**Transport
for NSW**

Exhibition of Preferred Project Report supporting Project Application for Rozelle Village/Balmain Leagues Club Development off Victoria Road, Rozelle (MP11_0015)

Detailed TfNSW and RMS Comments

Peer review of Rozelle Village Paramics Modelling

FIGURE 20 – VEHICULAR ACCESS POINTS

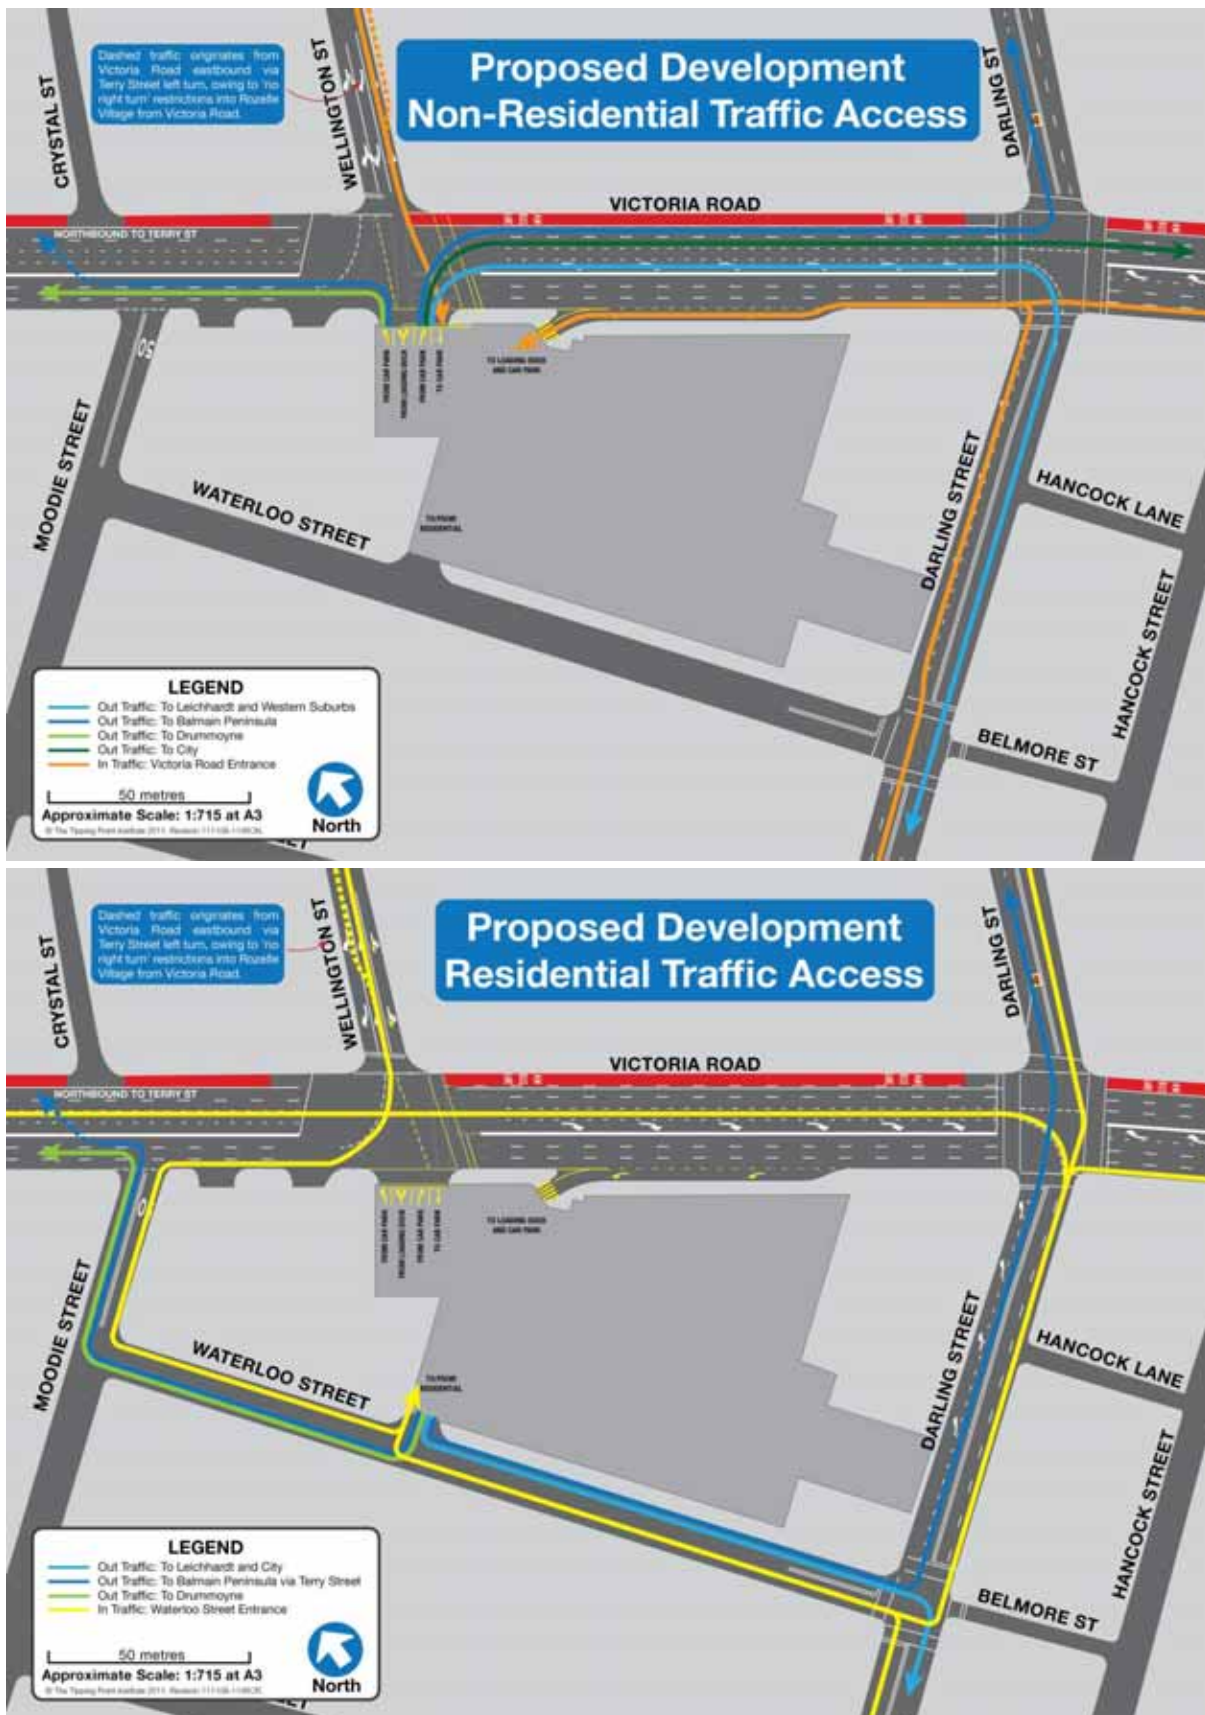
2. The following concerns are raised with regard to the geometric layout of the proposed modified signalised intersection of Victoria Road and Wellington Street:
 - a. The proposed exit ramps to Victoria Road from the proposed loading dock and basement car park are physically separated by pillars and are at different grades leading up to Victoria Road. This is a highly unorthodox road design. Concern is raised that motorists on these exit ramps will not have adequate sight distance to vehicles on adjacent exit ramps when exiting the subject site on a green phase. This restricted sight distance between exiting vehicles may require two separate signal phases for the proposed fourth leg on road safety grounds, which would create significant additional congestion on Victoria Road and would be unacceptable as

- b. There is a significant deflection within the proposed modified signalised intersection for through movements from Wellington Street into the subject site.
- c. Limited sight distance to pedestrians on Victoria Road for motorists exiting the subject site.

The applicant shall submit an independent road safety audit by a certified practitioner for the proposed modified signalised intersection on Victoria Road, which includes auditing the abovementioned safety concerns.
